**Re:** Planning Application 18/0992

**Address:** New Fold Garage Neville Street Longridge PR3 3FD

**Description:** Proposed additional valeting service to an existing garage operation and erection of 1.7m high Perspex panel screen.

**BLOCK PLAN**  
 1:500

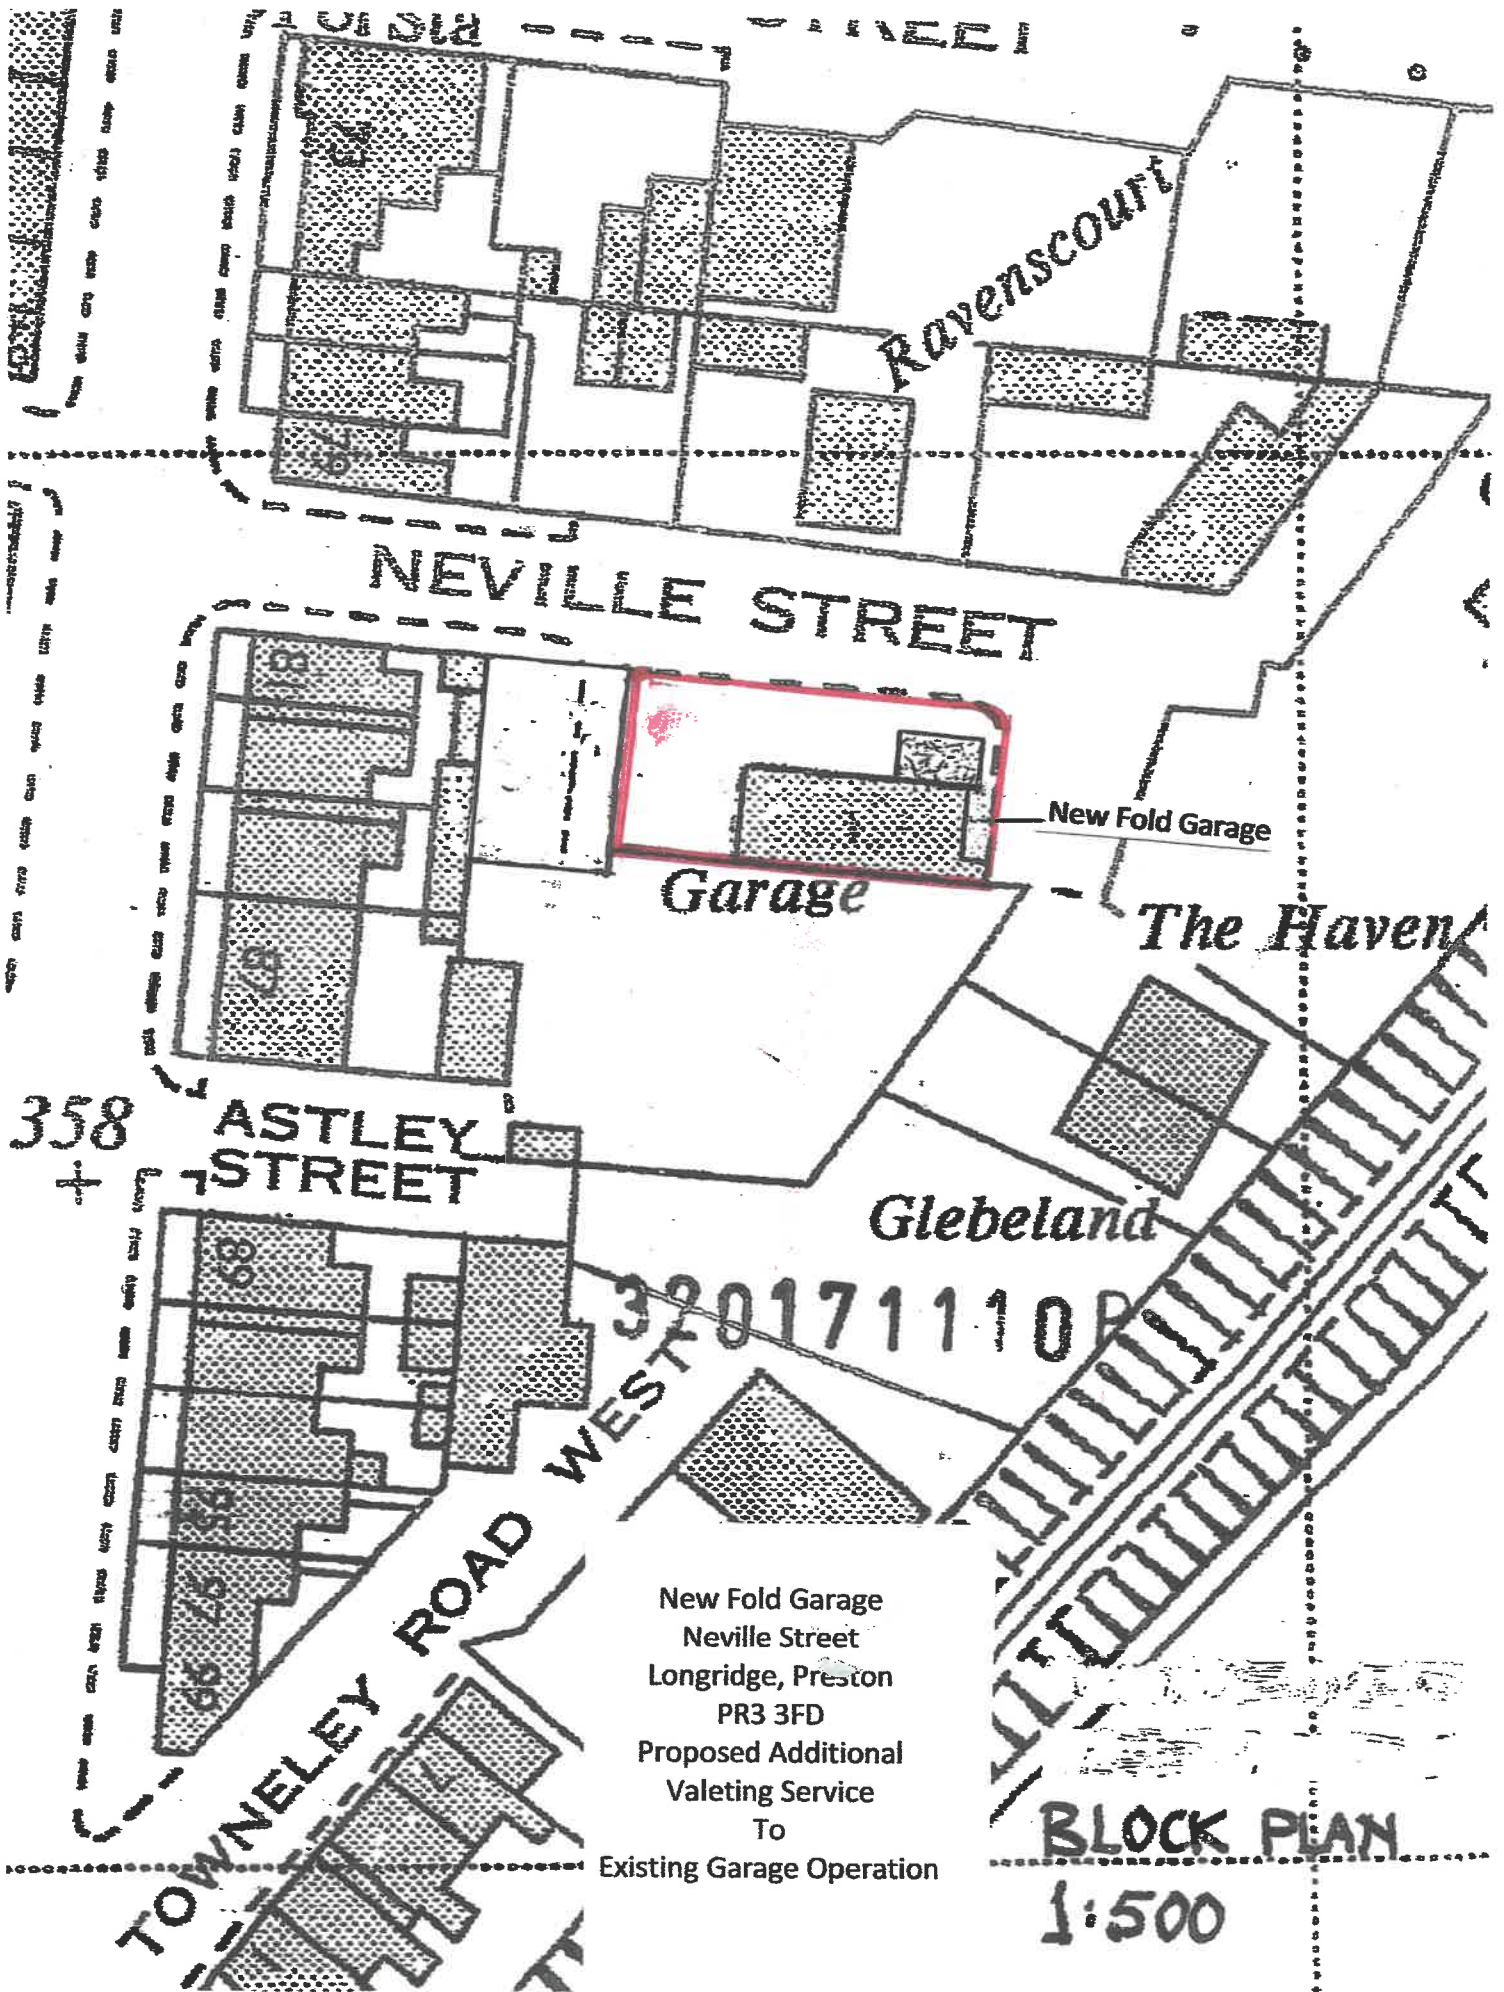
It is not apparent from the information provided as to how the potential vehicles to be washed are to be managed. It is expected that vehicles awaiting washing should be queued in such a manner, so as not to obstruct the highway or other highway users by blocking their access and egress to the adopted highway. Similarly, the positioning of the screen and washing facilities are likely to impede the manoeuvring space required for the garage to function.

In order to progress the application we would look for further information regarding the functionality of the site as a whole.
